Appeal Decision

Appeal Ref: APP/T2350/W/14/3001556

The Moorcock Inn, Slaidburn Road, Waddington, Clitheroe, Lancashire BB7 3AA

- The appeal is made under section 78 of the Town and Country Planning Act 1990 against a refusal to grant planning permission.
 - The appeal is made by Messrs S & A Thornber against the decision of Ribble Valley Borough Council.
 - The application Ref 3/2014/0592, dated 26 June 2014, was refused by notice dated 17 October 2014.
 - The development proposed is the demolition of the Moorcock Inn and the erection of 7 No. dwelling houses including associated drives, gardens and external landscaping works.
-

Drawing Title:
EXISTING FLOOR PLANS AND
ELEVATIONS

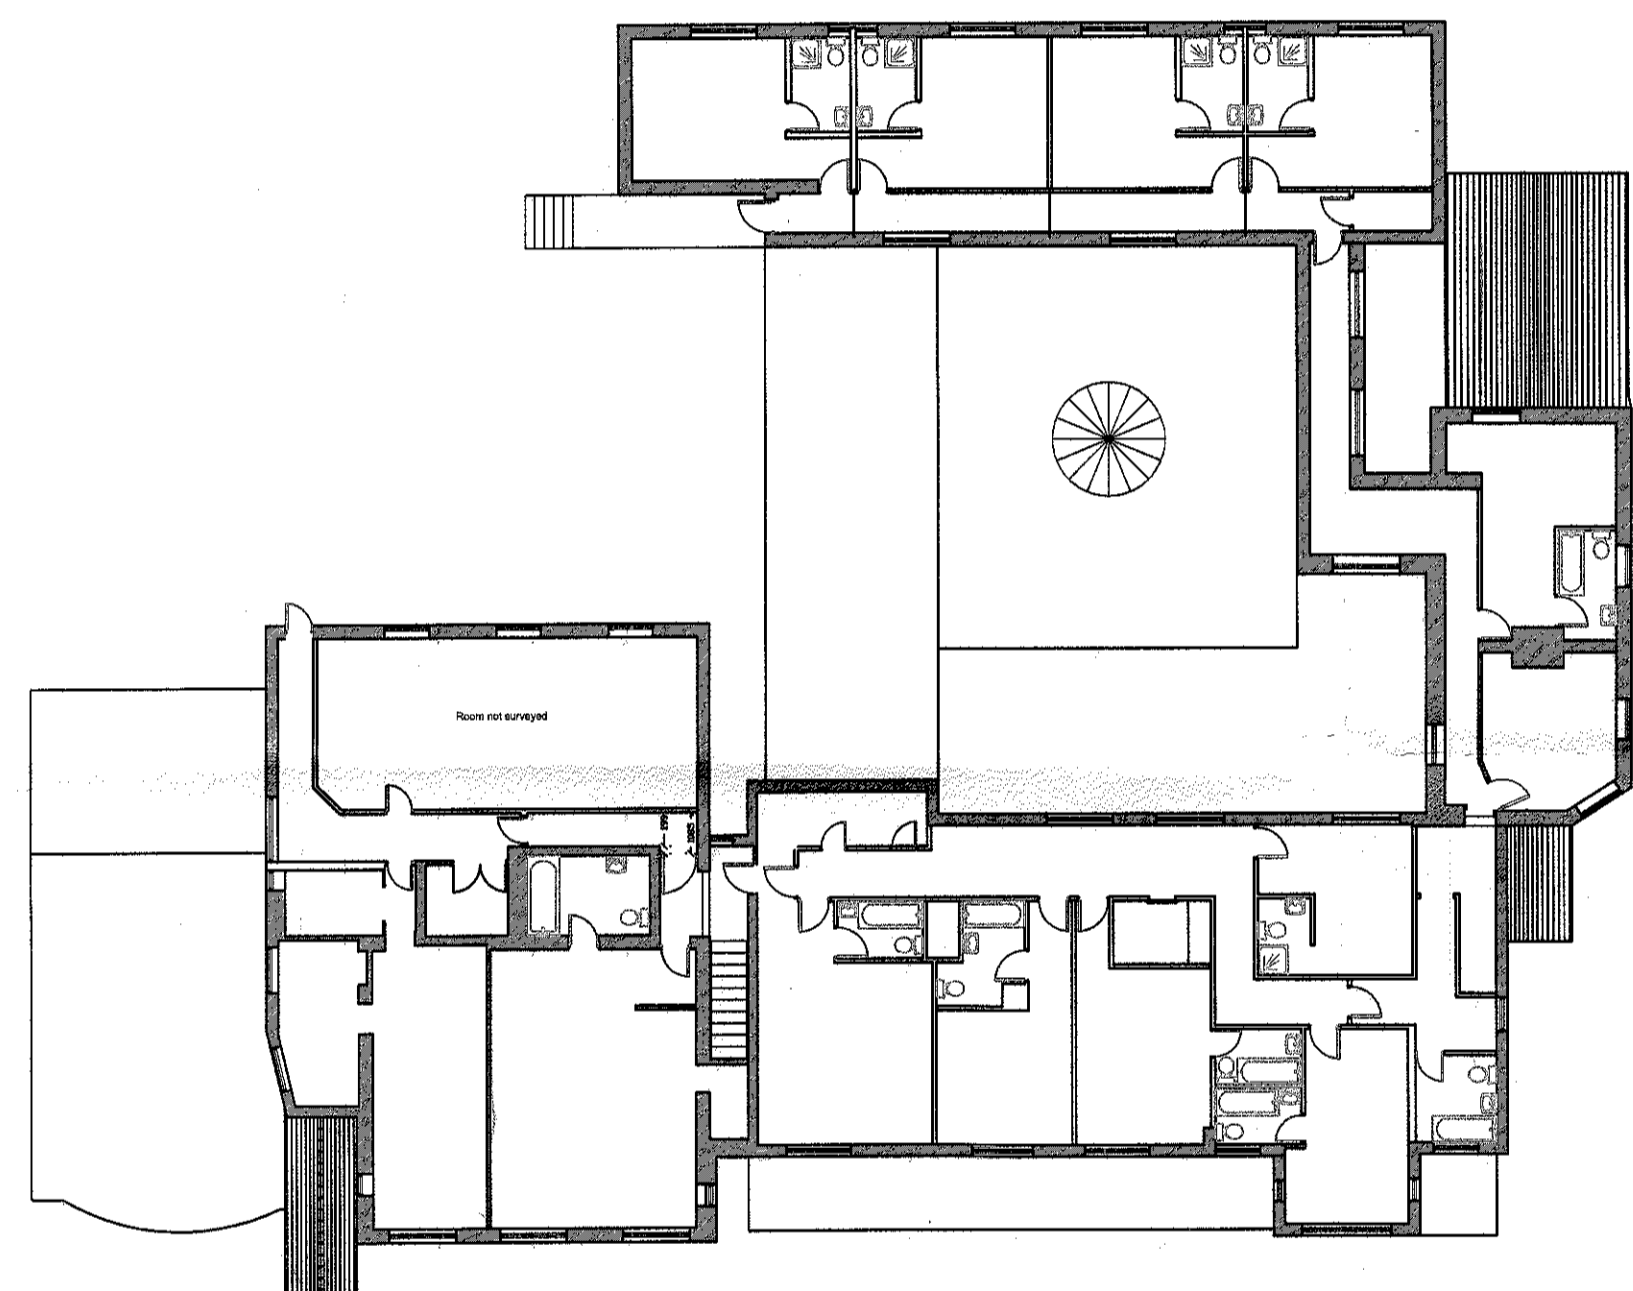
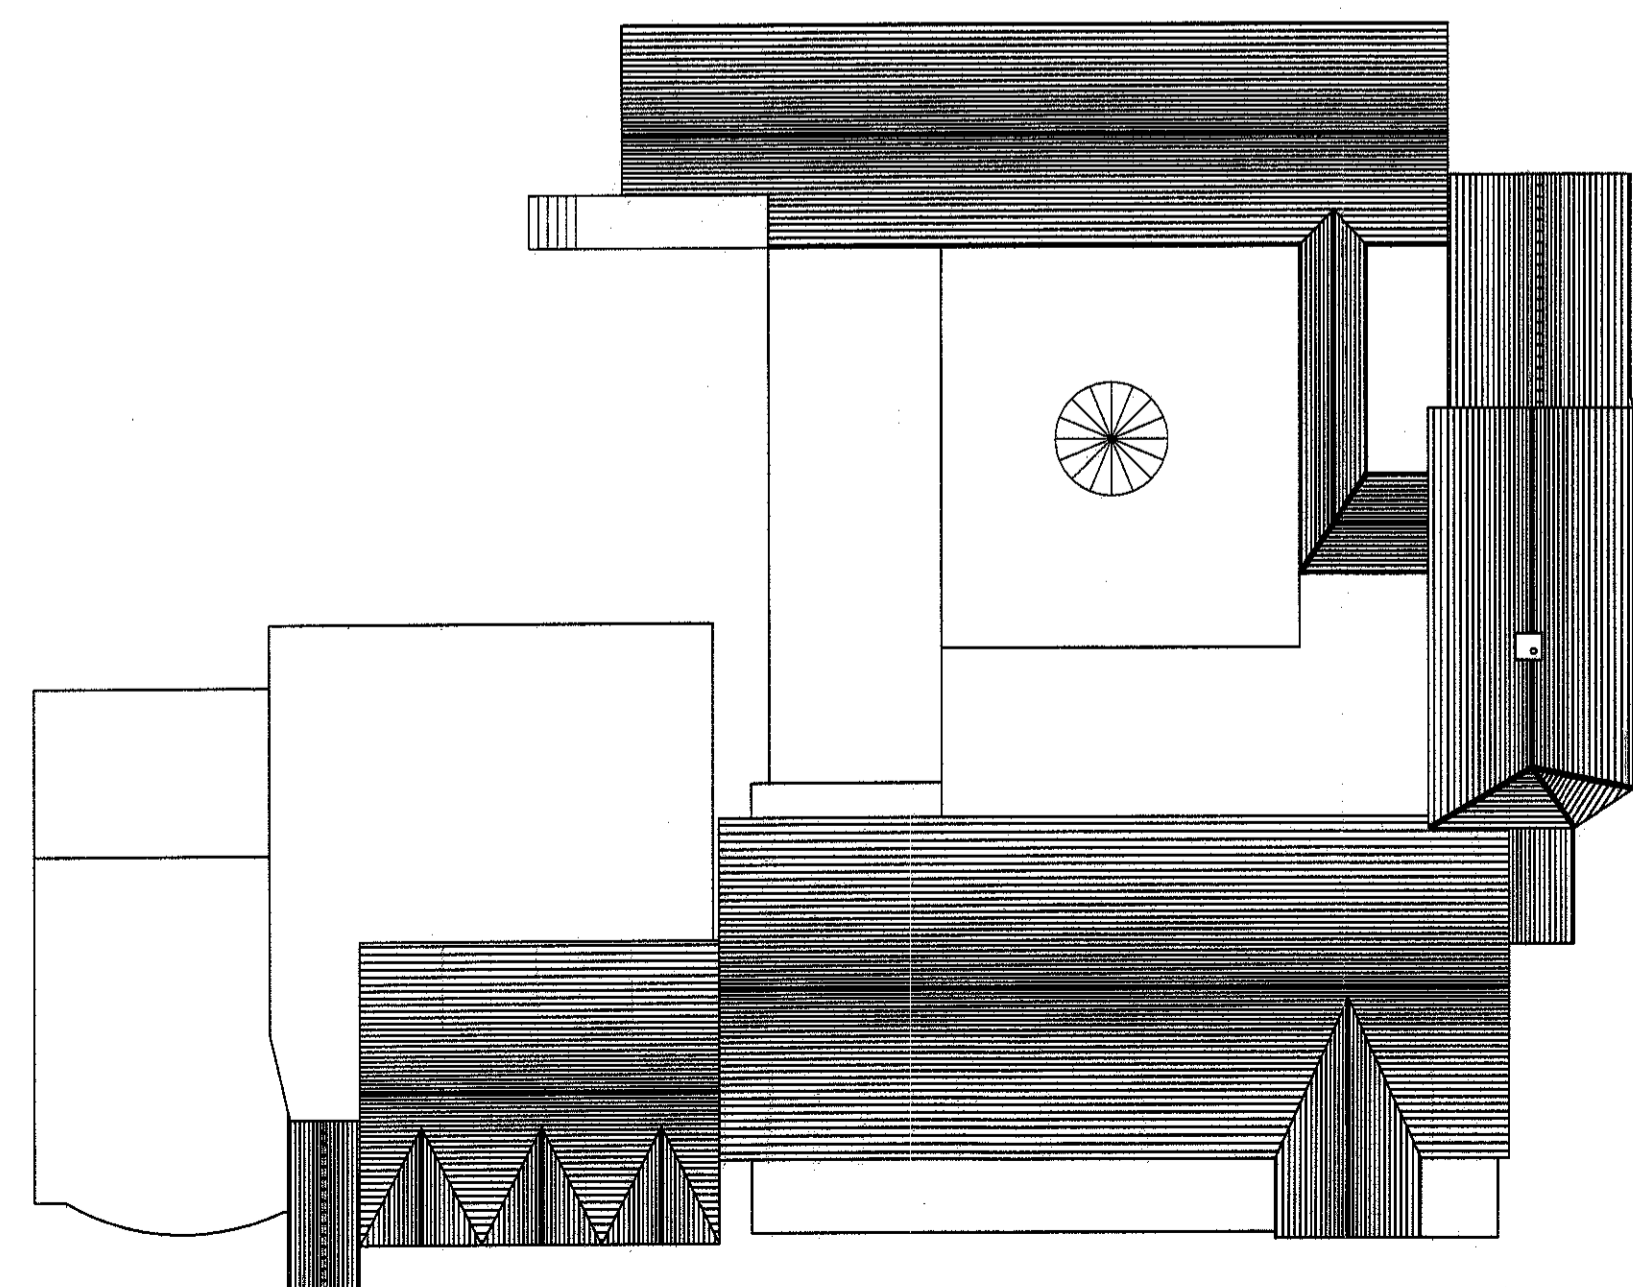
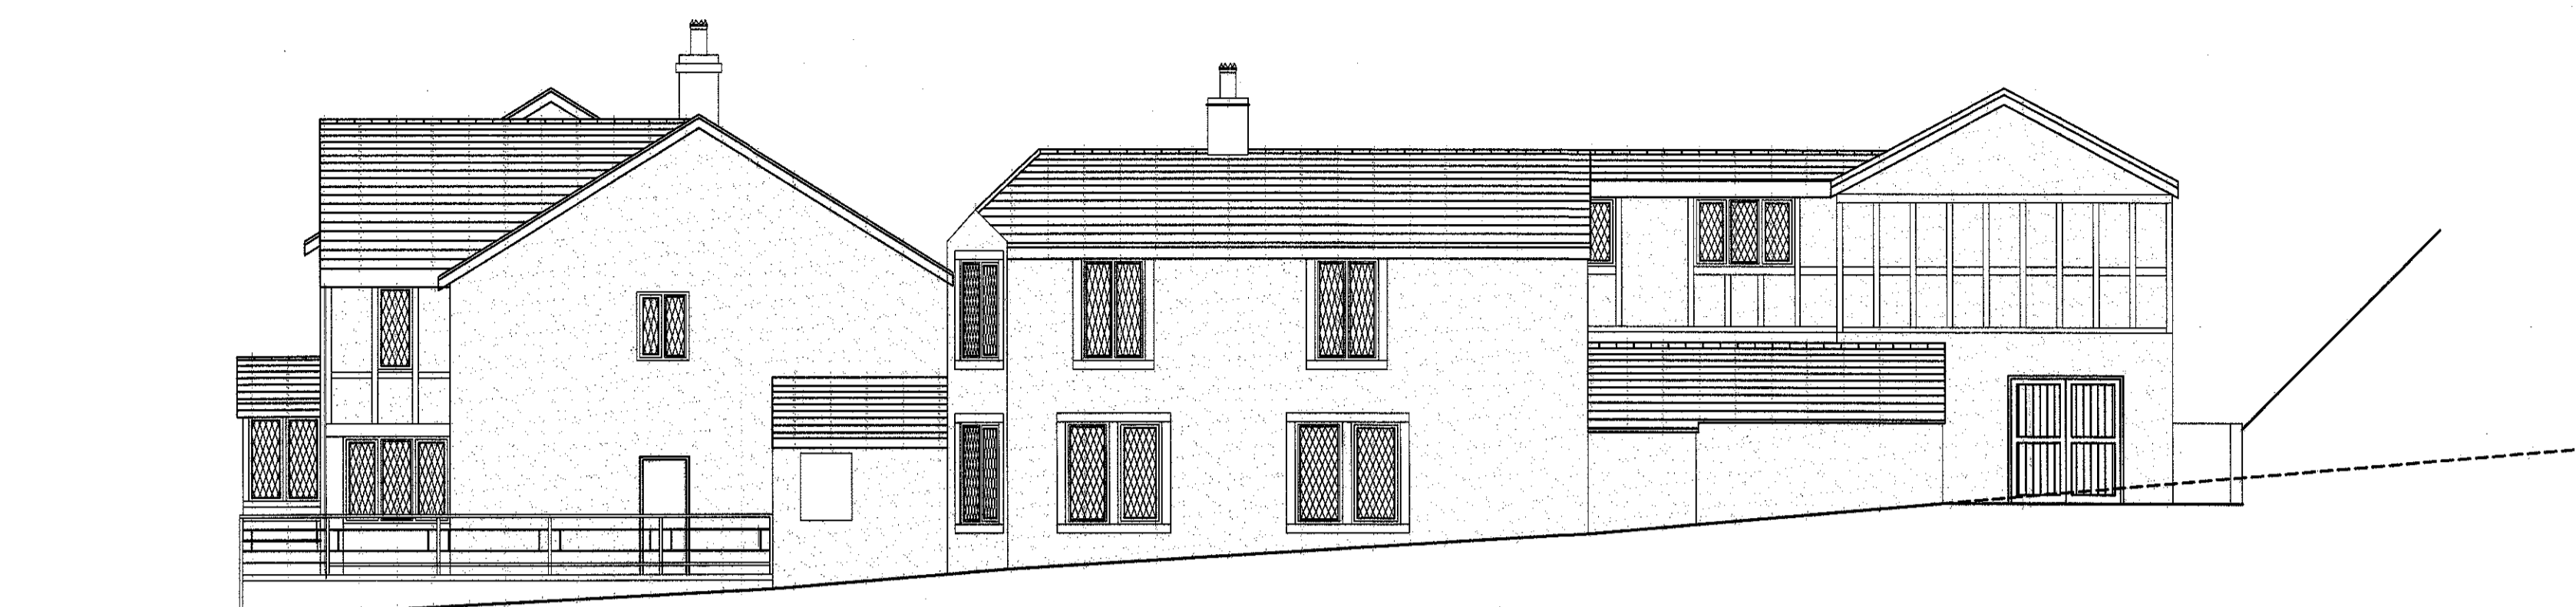
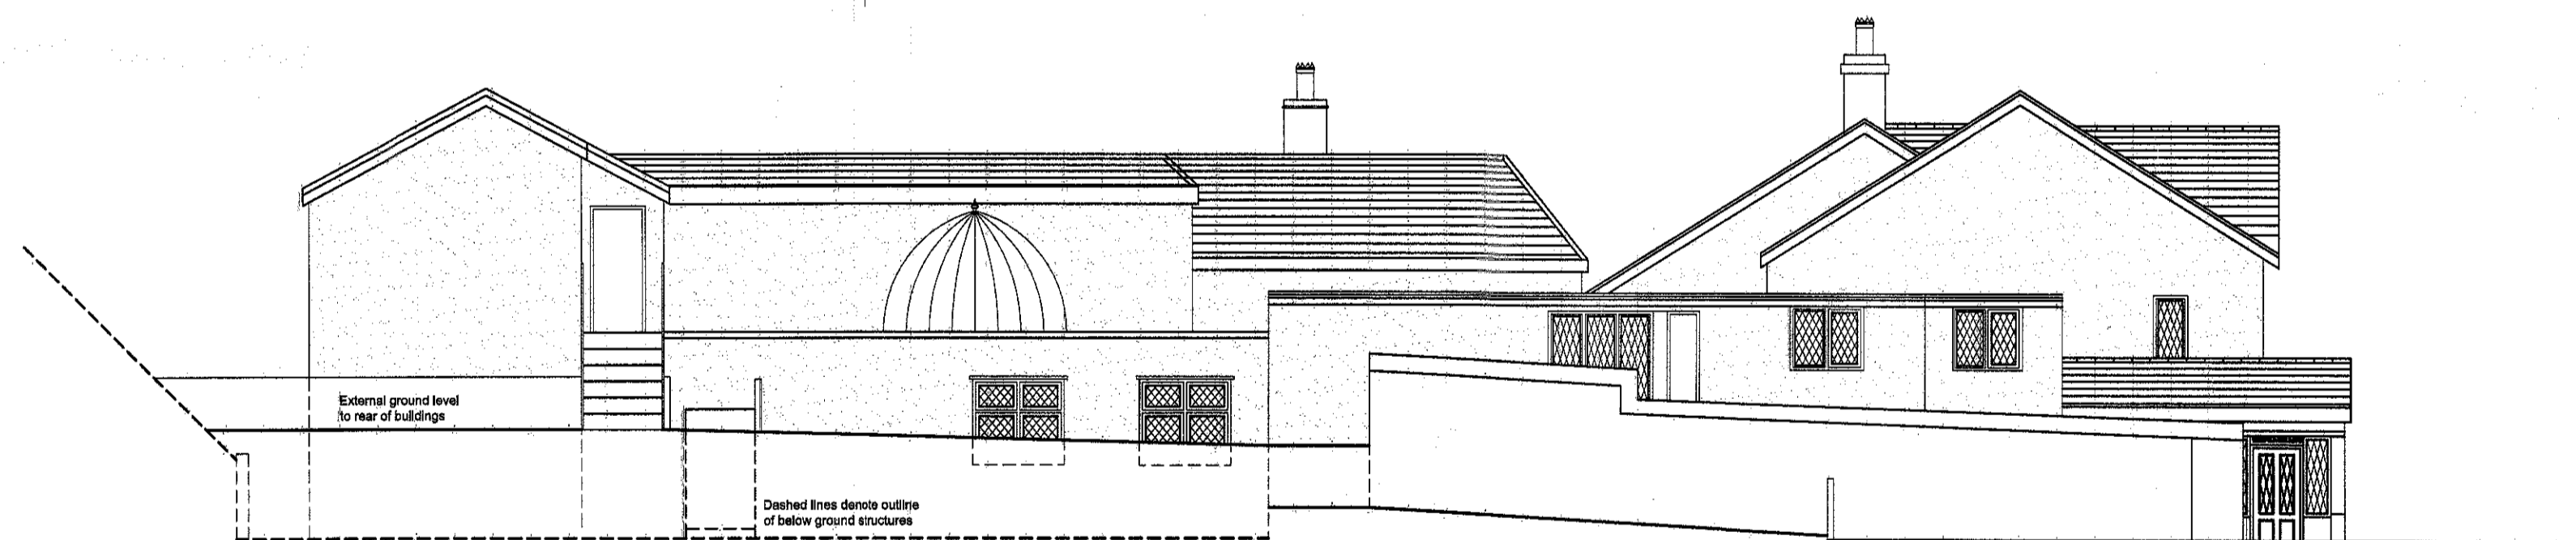
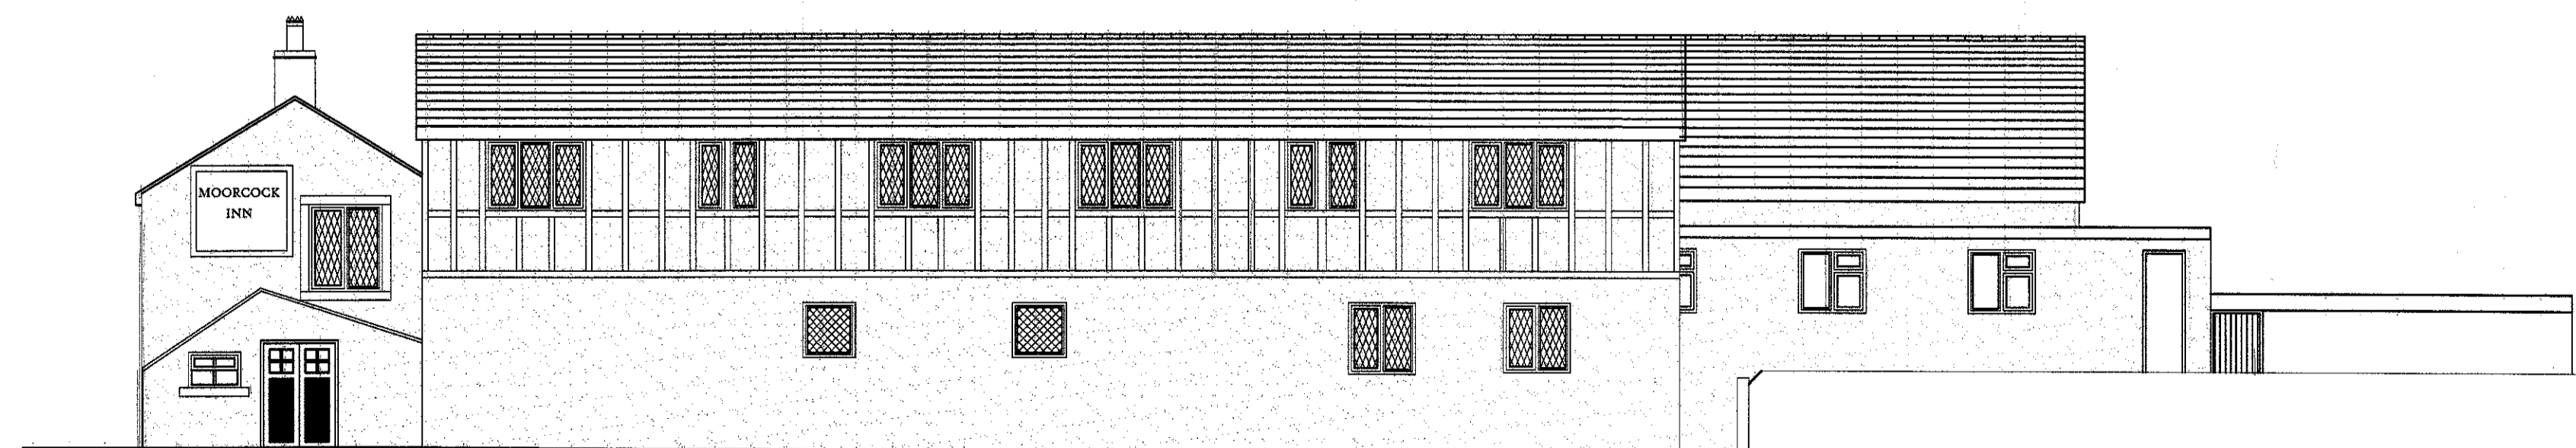
8. Both parties agree that the existing building has a detrimental impact on the AONB. I find that this arises from a combination of the significant massing of the poorly designed ad hoc extensions; the use of highly incongruent materials such as a rendered, mock-Tudor façade; its extensive car park; and the unsympathetic planting of ornamental conifer hedging. The site occupies a prominent position that is not only highly visible from the surrounding fells but also to the users of the adjacent Slaidburn Road, the B6478. Whilst views of the site are partially obscured to southbound road users, this is not the case for northbound road users who are able to clearly see the site from a considerable distance because of its elevated position.
